Application by Highways England for an Order Granting Development Consent for A57 Link Roads

Deadline 8 - response on behalf of High Peak Borough Council

Responses from High Peak Borough Council are provided in red to outstanding matters discussed in the hearing session held during the week commencing 4th April 2022.

**6.4 Environmental Statement  
Figure 5.4 Air Quality EU Compliance Risk  
Assessment**

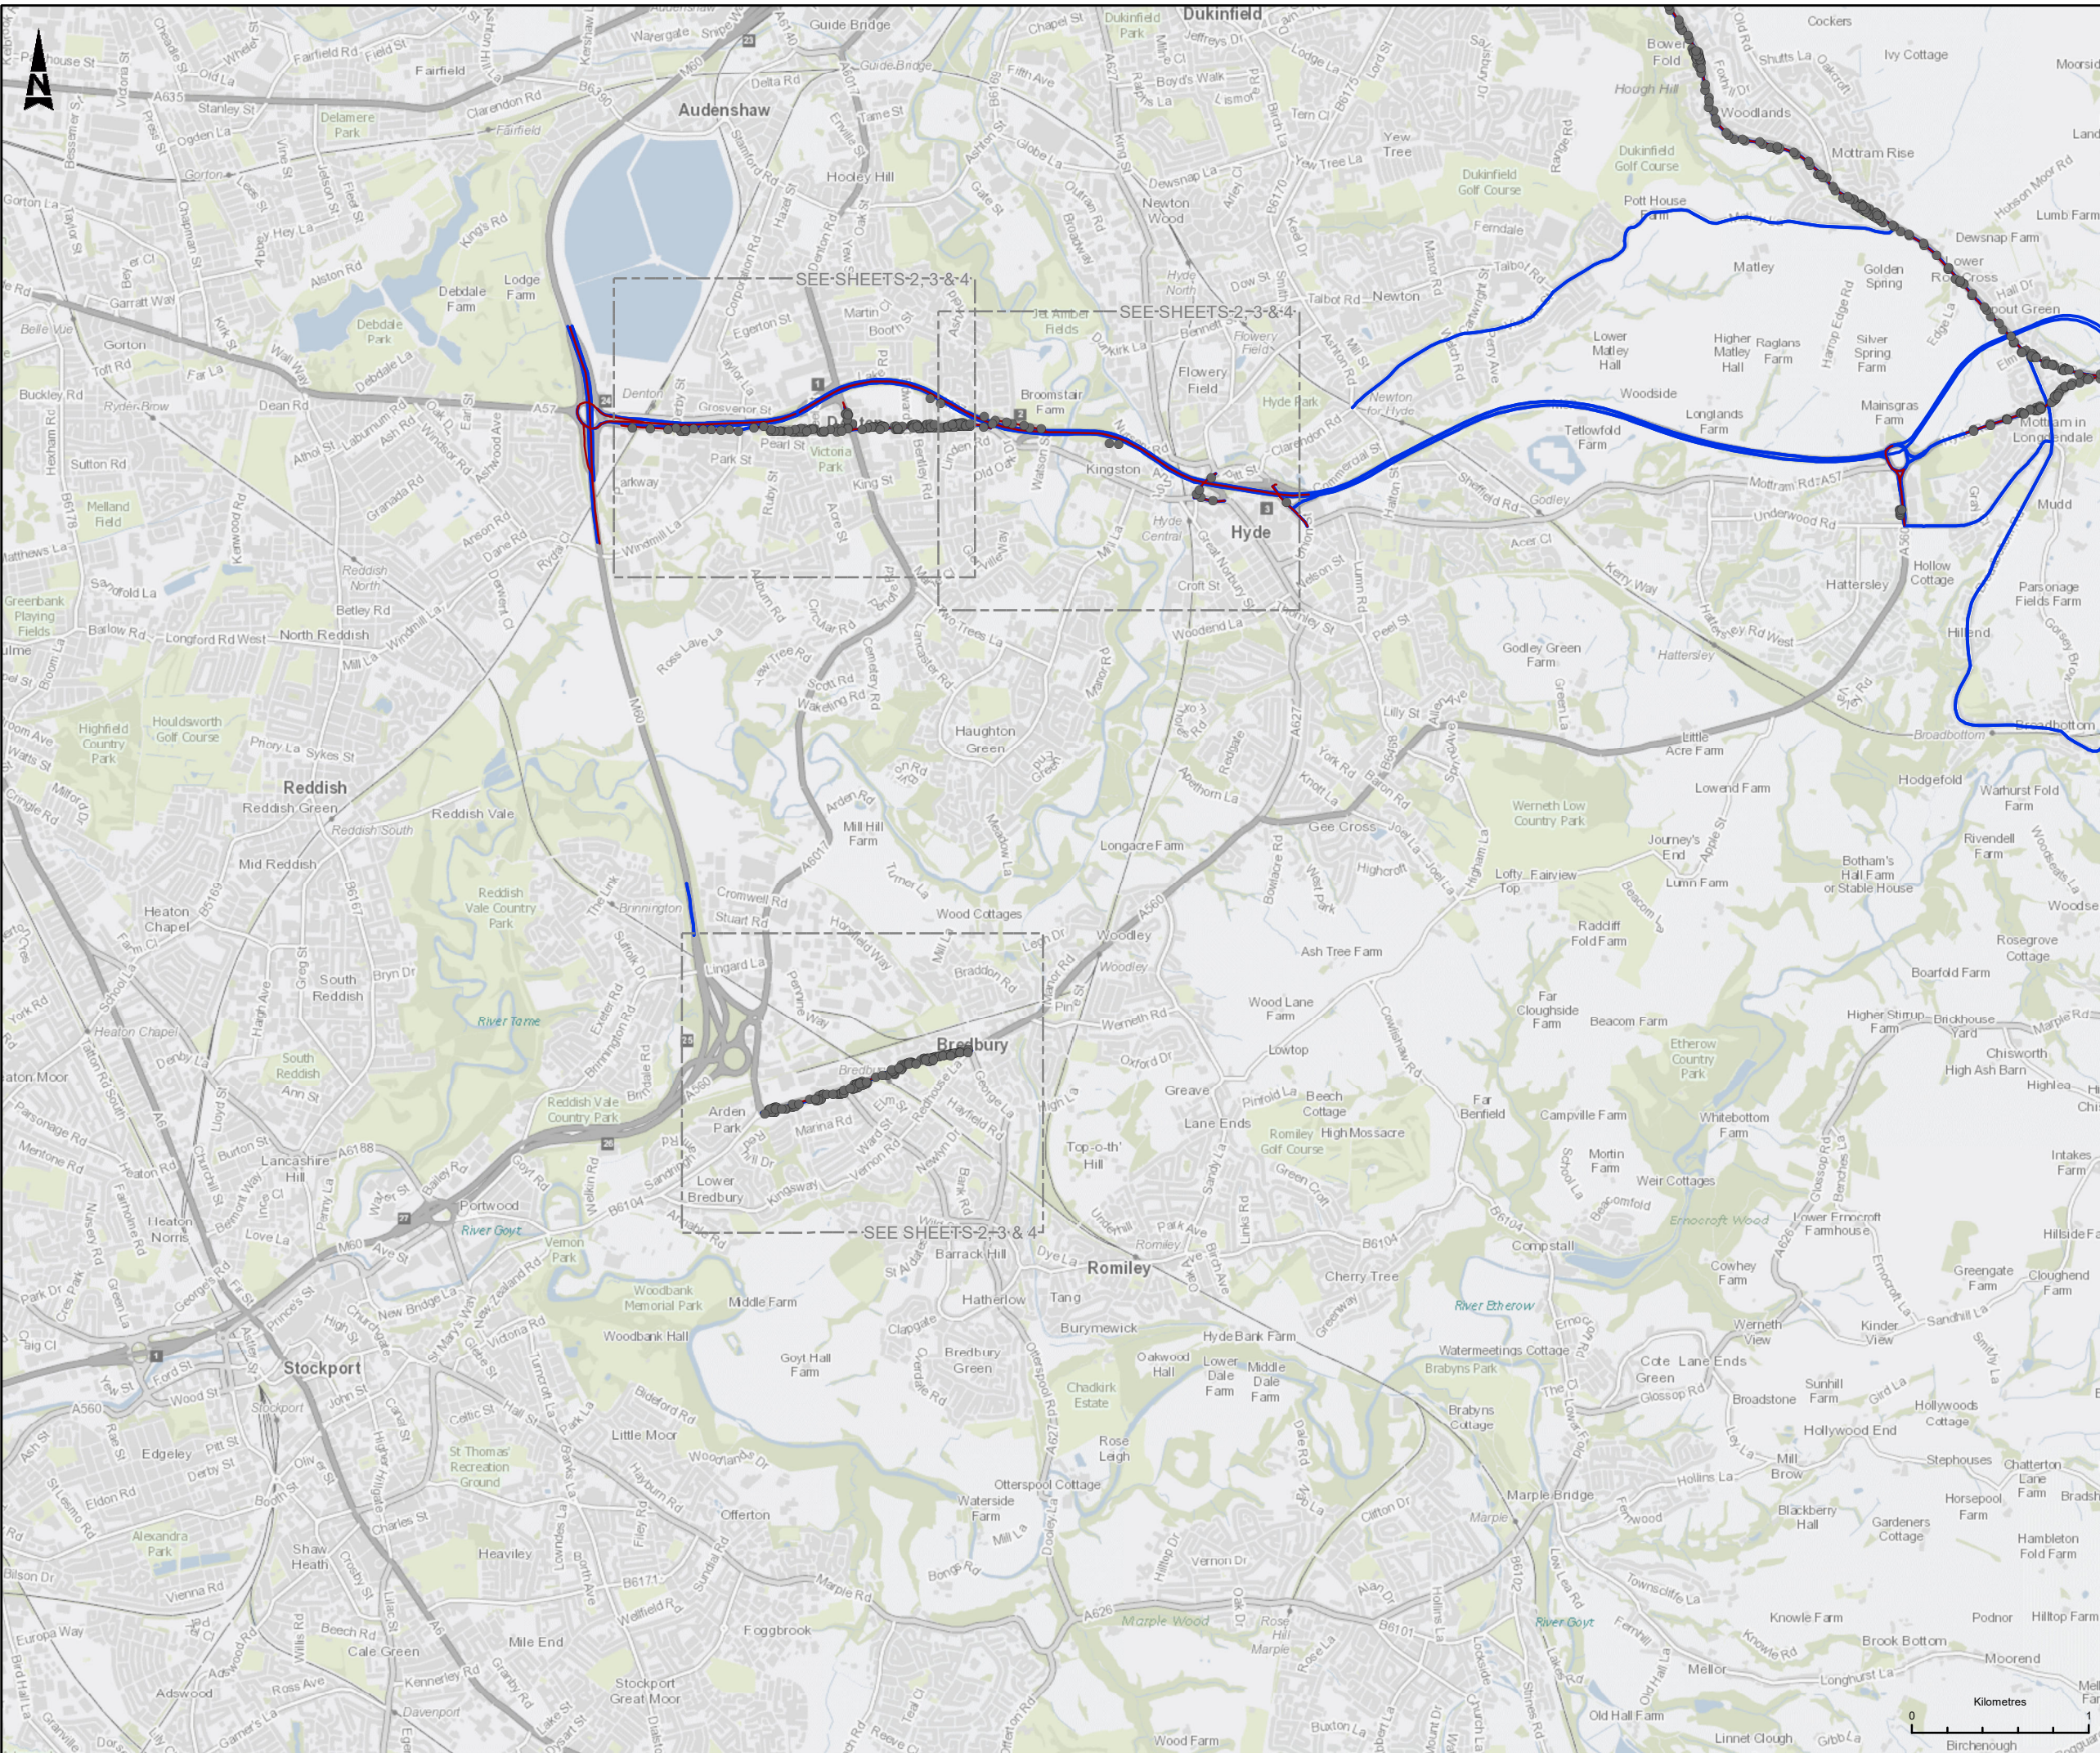
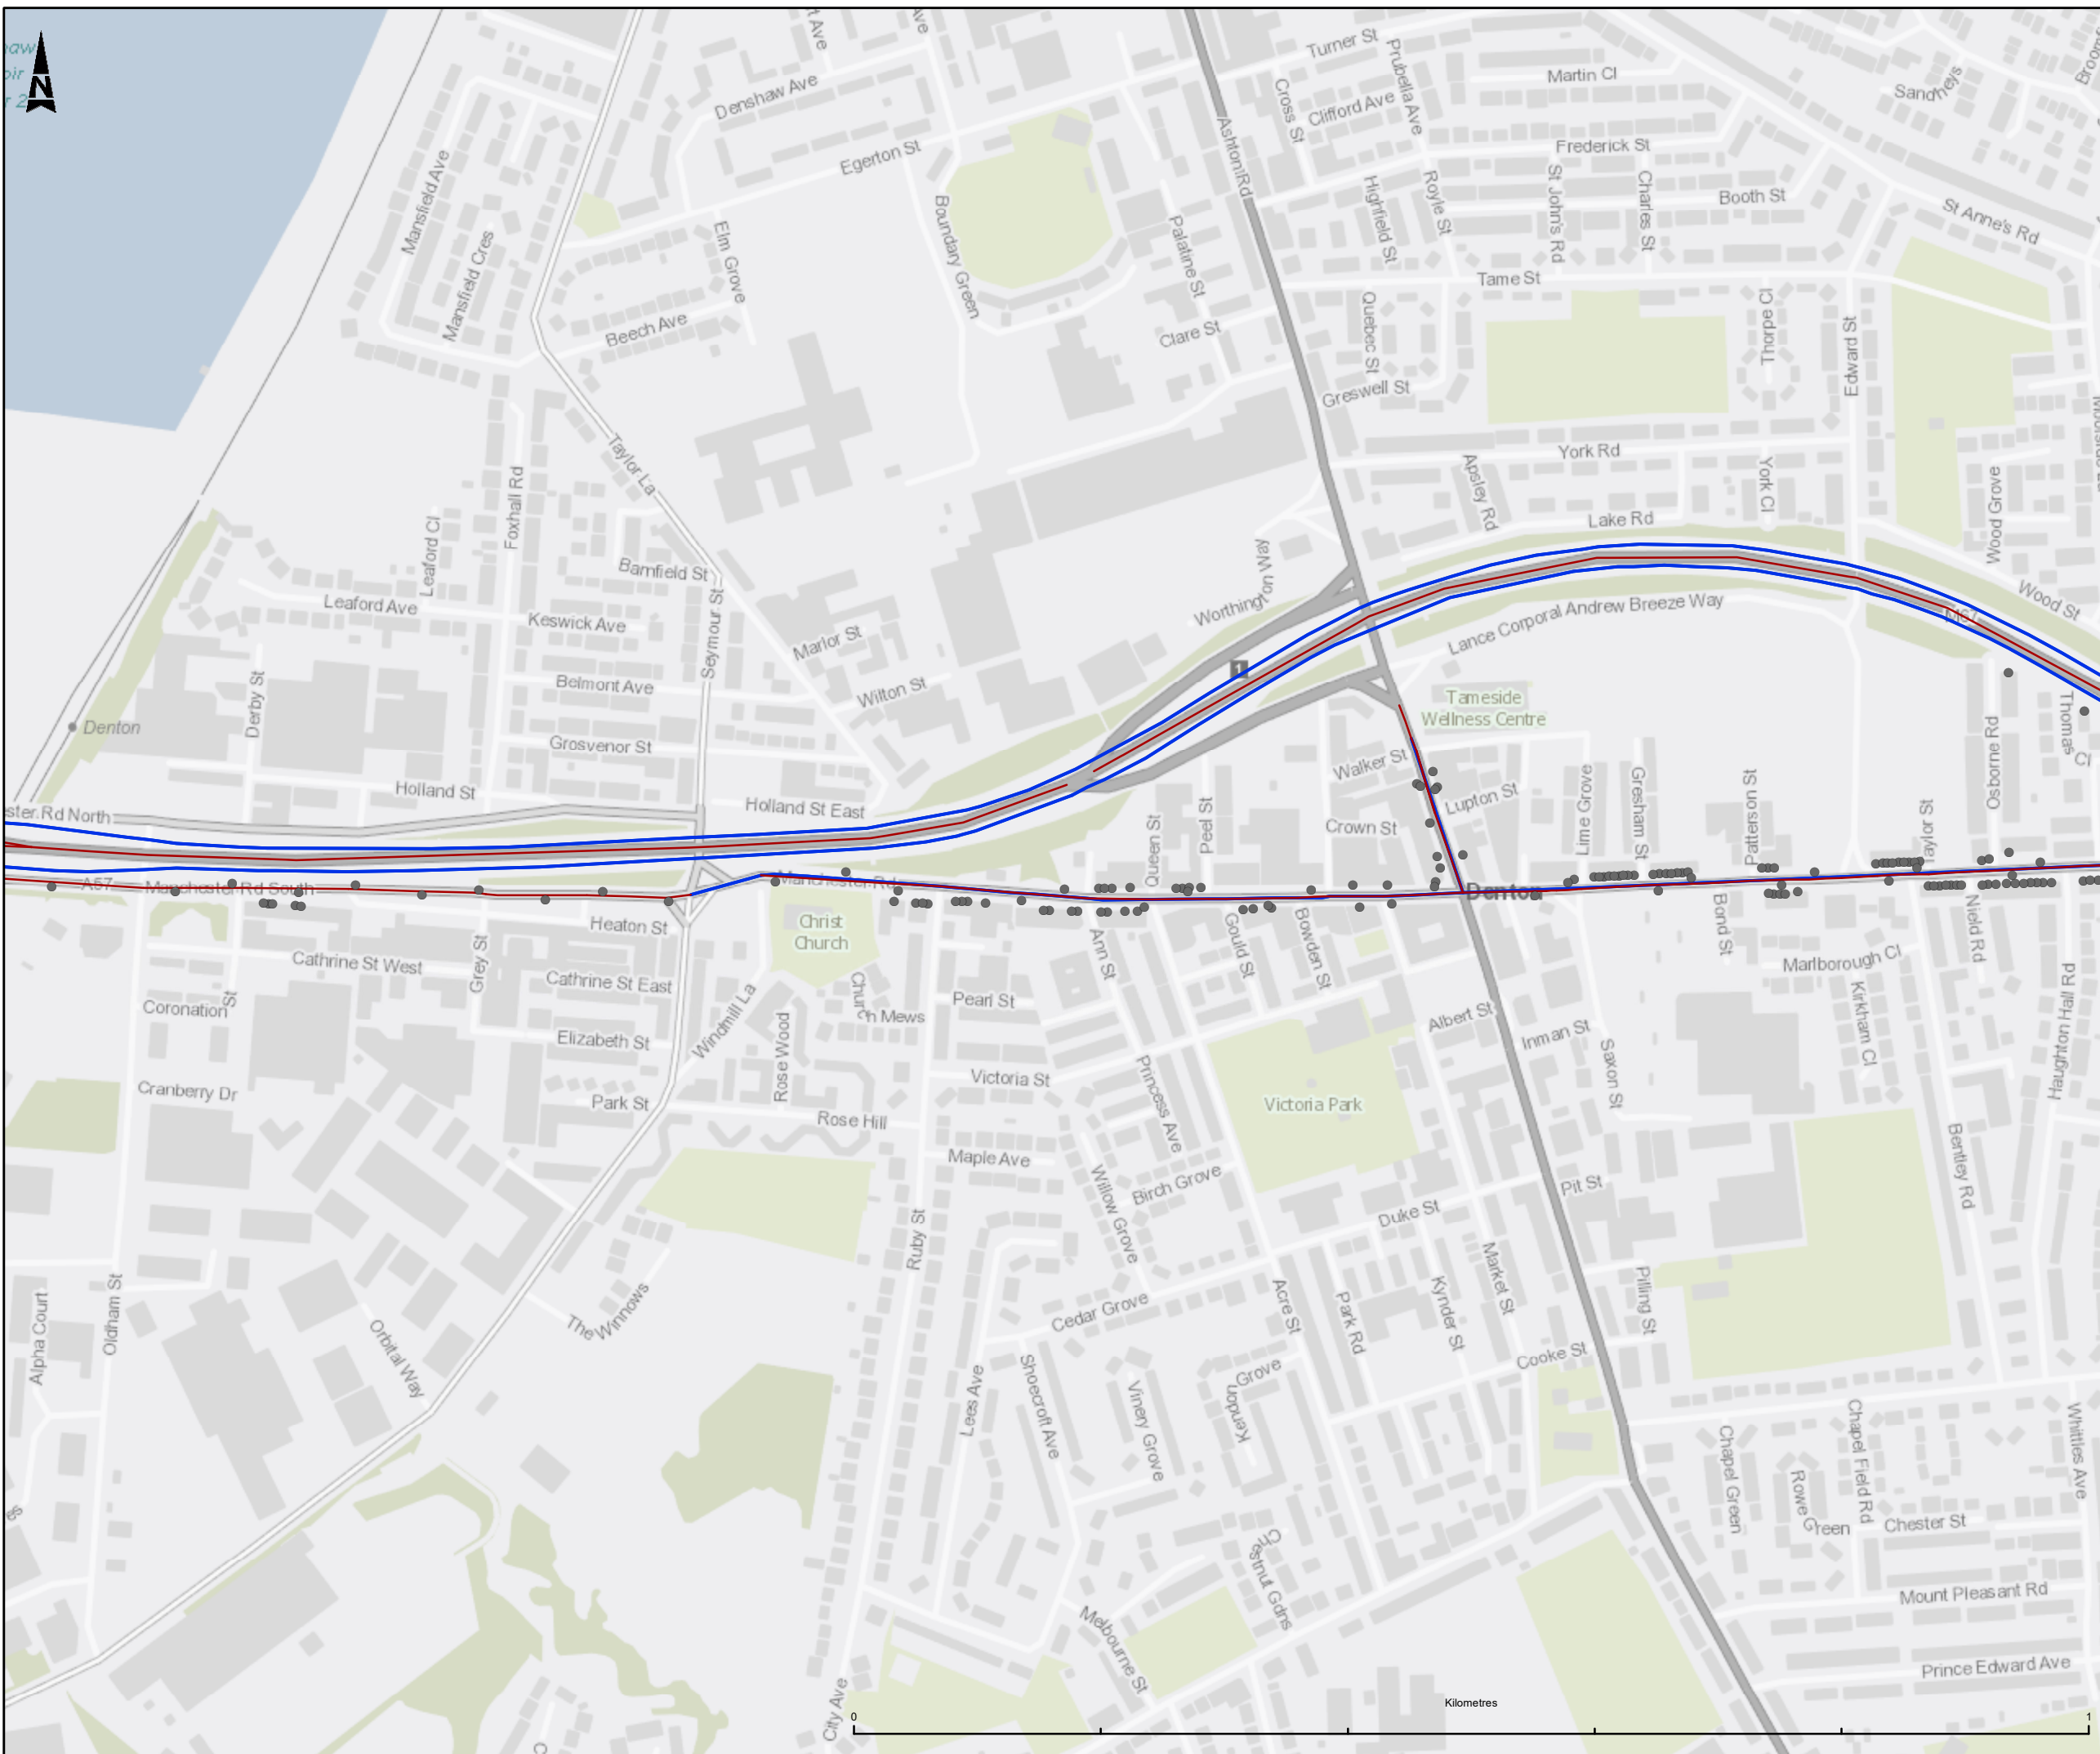
<u>Figure 5.4 Air Quality Compliance Risk Assessment – receptor labels</u>			
<p><u>Item 8.38</u> HPBC [REP4-011] asked for the A57 Brookfield qualifying features used in the NO2 compliance assessment to be</p>	<p>Given the number of qualifying features and public access receptors included in the compliance assessment it was not possible to practically label the qualifying features in ES Figure 5.4 (APP-080) however,</p>	<p>Agreed Deadline 8 update (HPBC) It is noted that this response was supplied at deadline 7 by NH. Clarification of receptors</p>	<p>Closed</p>

HPBC Item	National Highways Position	HPBC Position	Status
	<p>traffic scoping criteria requiring further assessment.</p> <p>The temporary traffic management measures will generally be short term, with the arrangements, timing and phasing being designed to minimise traffic congestion and delay far as reasonably practicable. Inevitably, however, some of the temporary traffic management arrangements are likely to cause some additional short term traffic congestion and delay within the immediate vicinity of the Scheme, but this is not anticipated to be sufficient to result in any material change in traffic flows or congestion on roads within HPBC.</p> <p>The approach to the assessment of the impact of construction traffic management has been further discussed and agreed with HPBC (virtual meeting held 4th March 2022).</p>		
<u>Human health receptors A57 Brookfield</u>			
<p><u>ISH 3 Item 5 Air Quality Question j</u></p> <p>Within the response to question j, HPBC raised a concern regarding the</p>	<p>Following further discussion and clarification with HPBC (virtual meeting held 8th April 2022) it has been agreed that a sensitivity test will be undertaken to identify the air quality impact at relevant qualifying</p>	<p>Deadline 8 update (HPBC) Further to Item 8.38; Identification of the receptors (figure 5.4) used in the compliance risk assessment</p>	<p>Open</p>

HPBC Item	National Highways Position	HPBC Position	Status
<p>magnitude of change reported in the compliance risk assessment at qualifying feature receptors adjacent to the A57 Brookfield.</p>	<p>feature receptors located adjacent to the A57 Brookfield under the DMRB LA 105 human health assessment methodology.</p>	<p>(using LAQM “conservative” forecast”) indicated that “large” change at some of the receptors along Brookfield. However, it also highlighted that some of these were human health receptors that had not been included as receptors in the (less conservative) primary human health AQ assessment (DMRB LA 105). Therefore, HPBC have requested that these receptors are also assessed in accordance with the DMRB LA 105</p>

HPBC Item	National Highways Position	HPBC Position	Status
labelled on ES Figure 5.4 [APP-080].	an extract of ES Figure 5.4 zoomed in on the A57 Brookfield area with receptor ID labels for qualifying features and public access receptors adjacent to the A57 Brookfield is provided below this table.	did highlight that there were some relevant receptors in the Brookfield area that had not been included in general AQ assessment but had been included in the compliance assessment (see final row)	
<u>Adjustment of Background Concentrations Data used in Air Quality Assessment</u>			
<p><u>Item 8.39</u></p> <p>HPBC raised concerns about the lack of adjustment to the background concentrations used in the air quality assessment. HPBC [REP4-011] suggest they are concerned about over representation of beneficial effects.</p>	<p>The HPBC query relates to the verification and adjustment of the Department for Environment, Food and Rural Affairs (Defra) mapped background concentrations. National Highways provided a response to question 8.39 in REP3-018. As stated in REP3-018, where the Defra background maps underpredict background monitoring data this could lead to a need to apply a higher adjustment factor in the air quality model verification. The higher the adjustment factor applied, the more conservative the results of the assessment given that the adjustment is applied to both the modelled total concentration with and without the Scheme, which has the effect of increasing the change in concentration. Where concentrations</p>	Agreed	Closed
